**Wildlife Trust for  
Beds, Cambs  
& Northants**

**Application by Anglian Water Services Limited for an Order Granting Development Consent for the Cambridge Waste Water Treatment Plant Relocation project The Examining Authority's second written questions and requests for information (ExQ2) Issued on 31 January 2024**

**Answer to Biodiversity Q5.3 – Ecological Impacts on Stow-cum-Quy SSSI**

Figure A.6: Stow cum Quy Fen SSSI

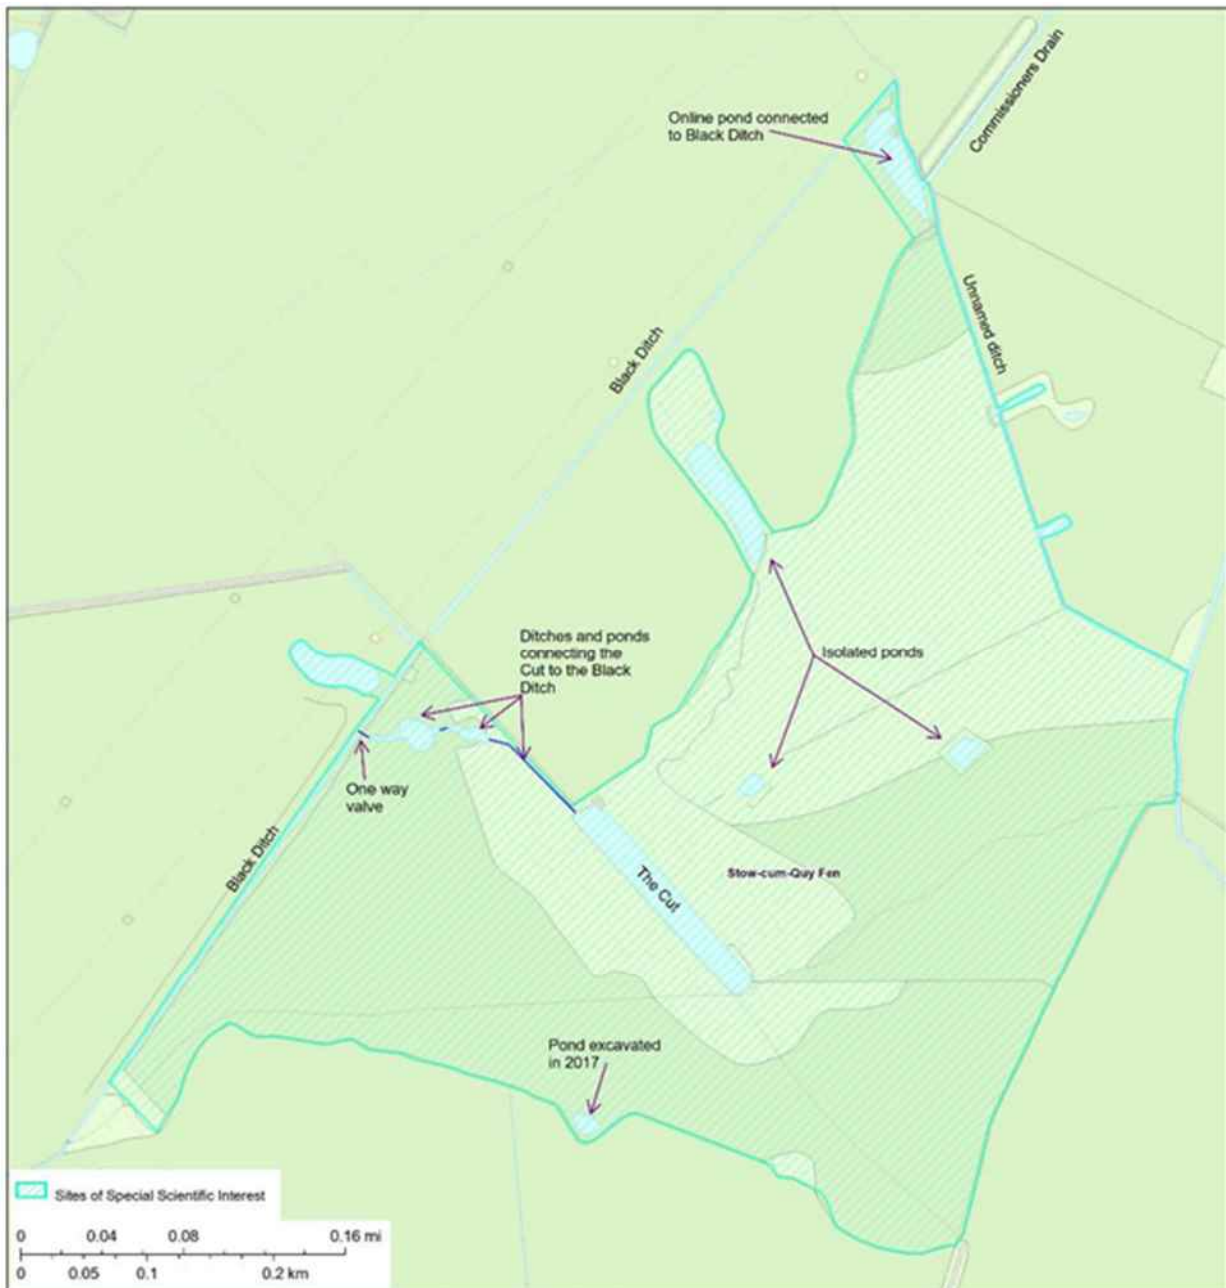
1. The potential for increased recreational impacts as a result on the opening up of the new permissive paths, with insufficient measures provided to measure the baseline situation and future impacts, nor to manage any impacts should they arise.
2. The potential from surface water pollution from the outfall to the CWWTP site via the Black Ditch.

The Wildlife Trust supported the stance taken by the Environment Agency and Natural England at that stage. The threat of groundwater or surface water pollution to Quy Fen SSSI must be avoided with negligible risk, taking account of catastrophic failures, during construction or operation of CWWTP. The risks from surface water pollution events via the Black Ditch have not been adequately addressed by Anglian Water.

With respect to ExQ 21.17, the Wildlife Trust believes that monitoring once a year is wholly inadequate, and even the EA / NE suggestions for more frequent monitoring still run the risk of pollution events being missed, which would be too late for Quy Fen SSSI. The scheme should be designed to avoid any prospect of such pollution impacts, with the necessary treatment measures put in place (either natural treatment wetlands or “end of pipe” solutions), as well as regular monitoring as suggested by EA / NE. Anglian Water should also specify the potential mitigation measures and operation changes they would implement should a pollution threat or incident be identified. With respect to ExQ 21.37 the monitoring must be undertaken (“should” is not acceptable).
